Re: American Furniture Demolition at 3535 Menaul Blvd. NE
Erosion and Sediment Control Drawing
Response to Submittal #2 Comments

E2RC, LLC ("E2RC") has reviewed your comments dated April 19, 2024 on the second erosion control plan ("ECP") for the American Furniture Demo project. Per your comments, you may find the changes requested as summarized below:

GUZMAN CONSTRUCTION SOLUTIONS, LLC  
AMERICAN FURNITURE  
DEMOLITION & EARTHWORK  
SWPPP NOTES

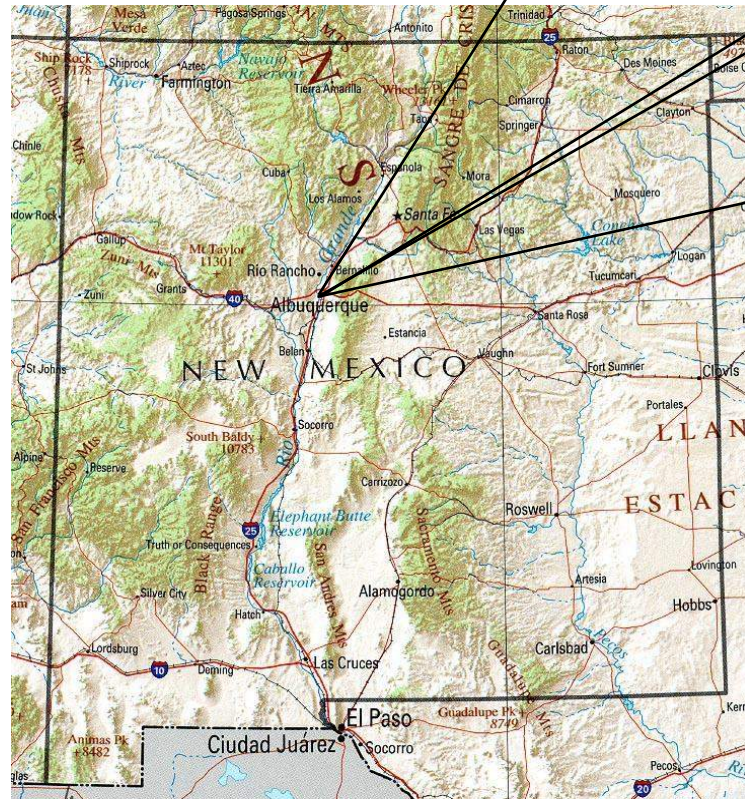
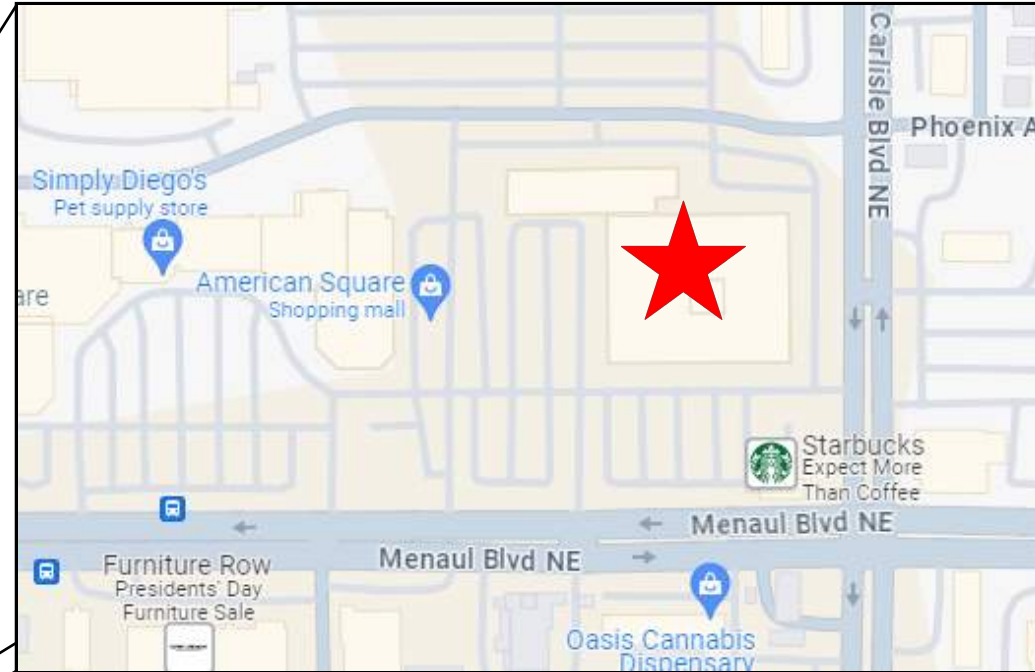
2. The sequence of construction activities is outlined on page 2. Your specific request to revise the stormwater pond notes is complete on pages 2, 9 and 10. Your comments discuss a berm, however, no berm is anticipated as the stormwater ponds volume will be created by excavation. We retain the detail to construct the ponds when the asphalt is removed. Understandably, the excavation cannot occur while the asphalt remains. We clarify your comment, "The Sediment traps and the berm are the first items of construction, along with the rest of the temporary stormwater controls" further to acknowledge other COA departments may require above – ground controls to be installed before the ponds. The project schedule is included in the SWPPP as the schedule may change. The *Living Document Rule* allows the Operators to update the schedule as needed.

GUZMAN CONSTRUCTION  
SOLUTIONS, LLC  
AMERICAN FURNITURE  
DEMOLITION & EARTHWORK  
DEMOLITION NOTES

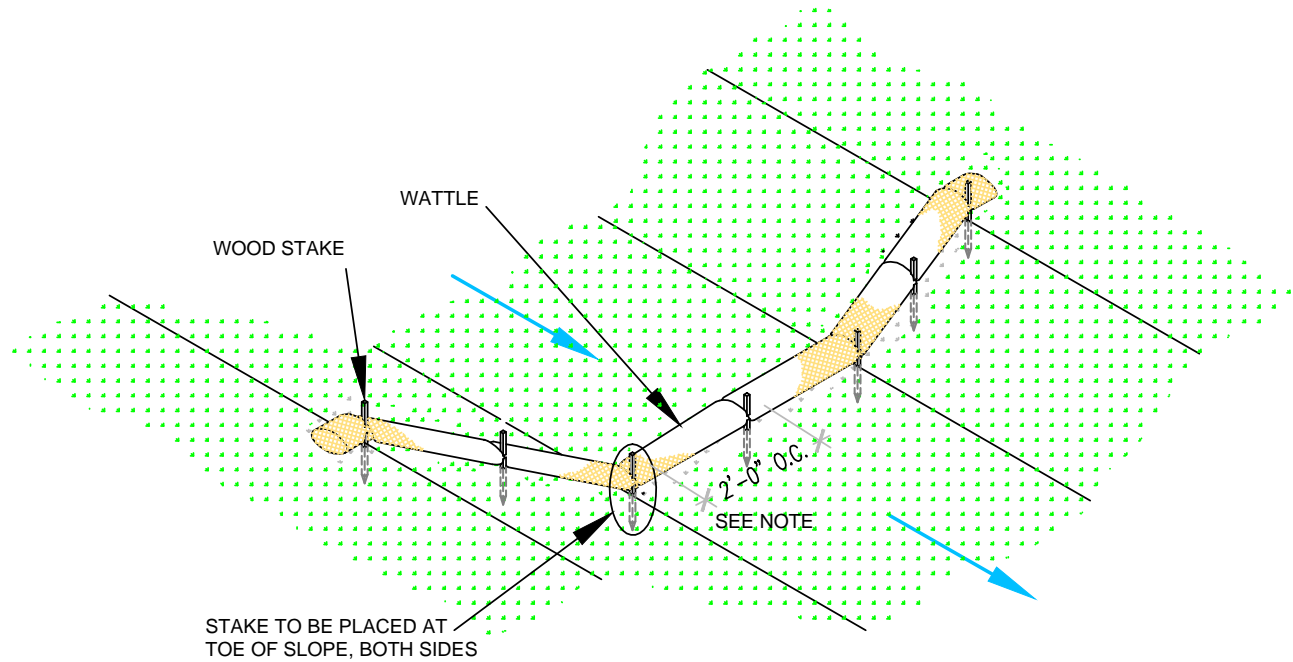
1. The note on the waste containers is on page 3. E2RC added the additional NPDES requirements you highlighted for projects which are demolishing structures built before January 1, 1980 and over 10,000 square feet and also discharging to waterbodies that are impaired for PCBs to page 3.
